Online Comment

Application H15-0955-25
Location Kirk Hill 355 Westhorpe Road Gosberton Westhorpe PE11 4ER
Proposal Extension to Existing Agricultural Building for Plant/Machinery, Storage & Workshop - Retrospective

Name Ruben Lopez Catalan
Address Lincolnshire County Council, County Offices, Newland, Lincoln LN1 1YL
LN1 1YL

## Existing Floor Plan SCALE 1:100

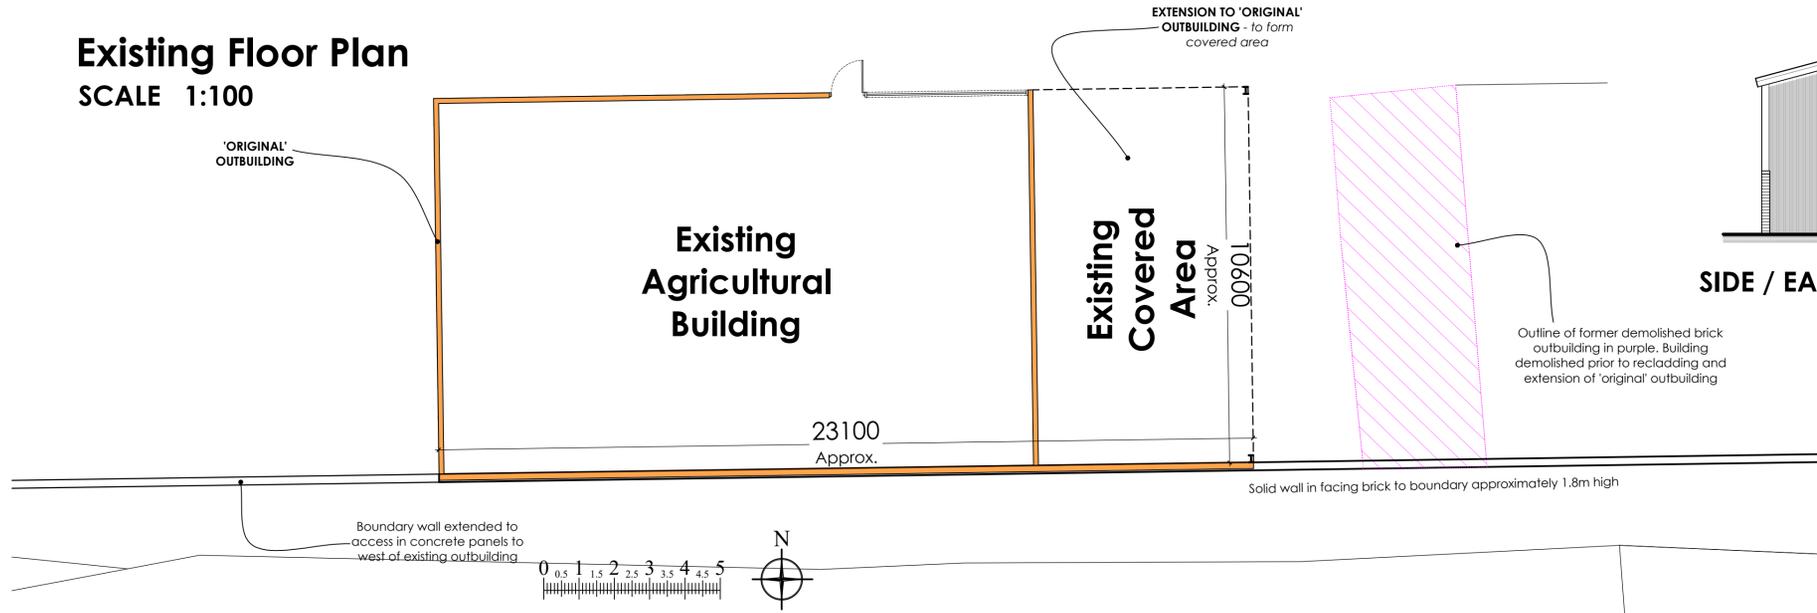
The demolished building is part of MLI122465 Kirkhill Farm (Kirk Hill House), Quadring: Kirkhill Farm (Kirk Hill House), Quadring. Partially extant 19th century farmstead. Regular courtyard of F plan. The farmhouse is detached from the main working complex. There has been a partial loss (less than 50%) of traditional buildings. Isolated location. Large modern sheds are located to the side of the site.

Recommendation: Currently there is insufficient specific information on the heritage potential for the site and the extent of impact to a heritage asset from the proposed development. Therefore, I recommend the applicant to provide the results of a full Heritage Impact Assessment of the building. This is in line with the guidance set out in the NPPF 2024 (paragraphs 207 & 218). The applicant has not adequately described the significance of any heritage assets that may be affected by the proposed development, and it is not "sufficient to understand the potential impact of the proposal on their significance (the heritage assets)" (Paragraph 207 of the National Planning Policy Framework (NPPF)). This in turn does not allow the Local planning authority to "identify and assess the particular significance of any heritage asset that may be affected by a proposal." (Paragraph 208 NPPF). Given the very high heritage potential, I recommend this application to be accompanied by the results of a full Heritage Impact Assessment in order to properly assess the site potential, inform the appropriate planning advice and design an appropriate mitigation strategy should consent be subsequently granted.
